Regarding <https://www.kirklees.gov.uk/beta/planning-applications/search-for-planning-applications/detail.aspx?id=2021%2f93621>

It is sometime since this last went out to the public for consideration and once again we do want to reiterate that we do not want to be NIMBY's and do appreciate that as outline planning permission has previously been granted for this plot of land that it is very likely that you must grant planning permission to this new application. However, we do hope that you will take into consideration some of the following points to ask the developers to resubmit a more suitable application for your to approve rather than this current application.

Appendix 2: Draft tree protection plan

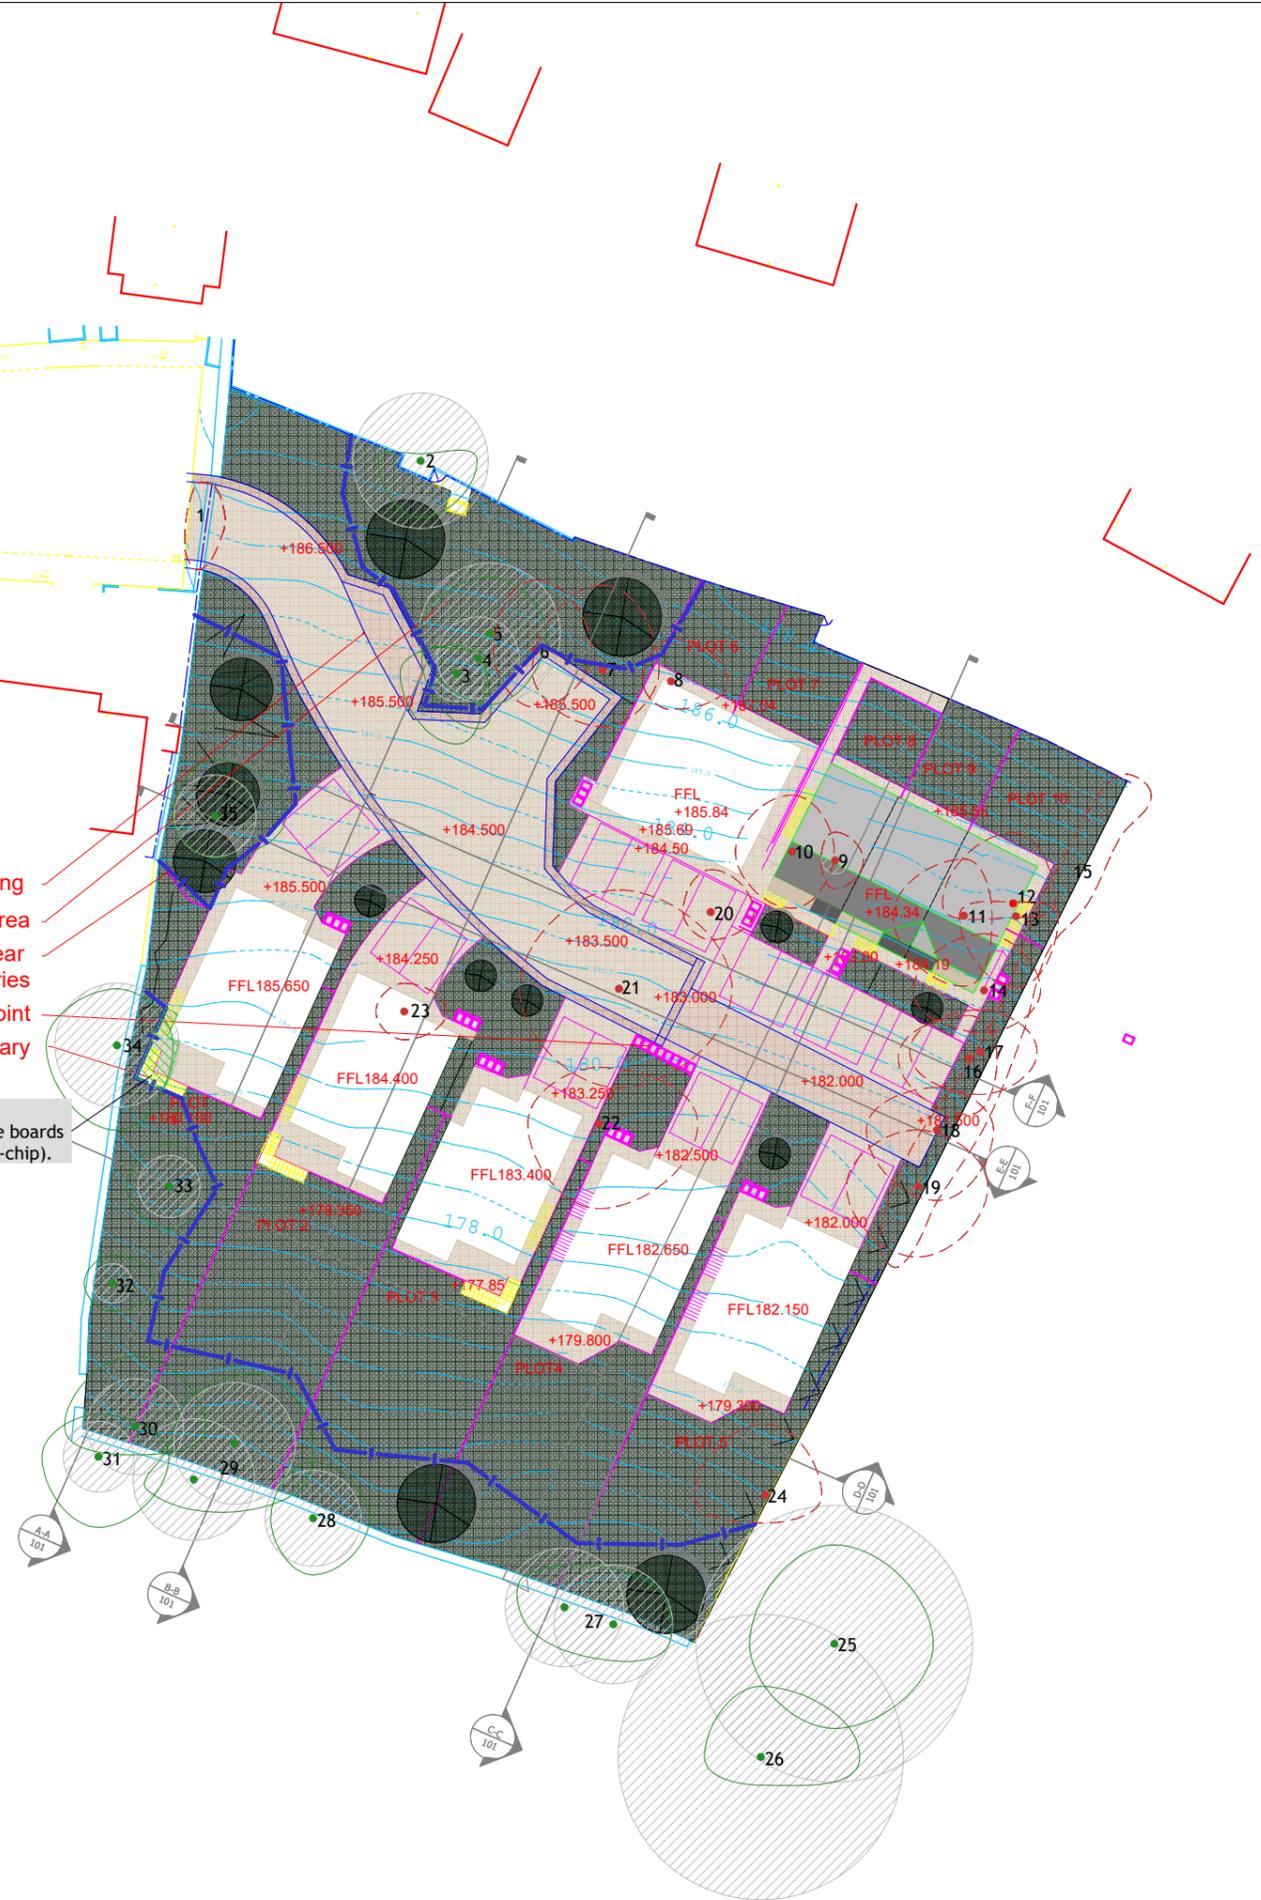
On the current plans there are less trees being retained and the main central tree that on the report that was classed as Category B, tree T25, now appears to be part of the area that is to be built on.
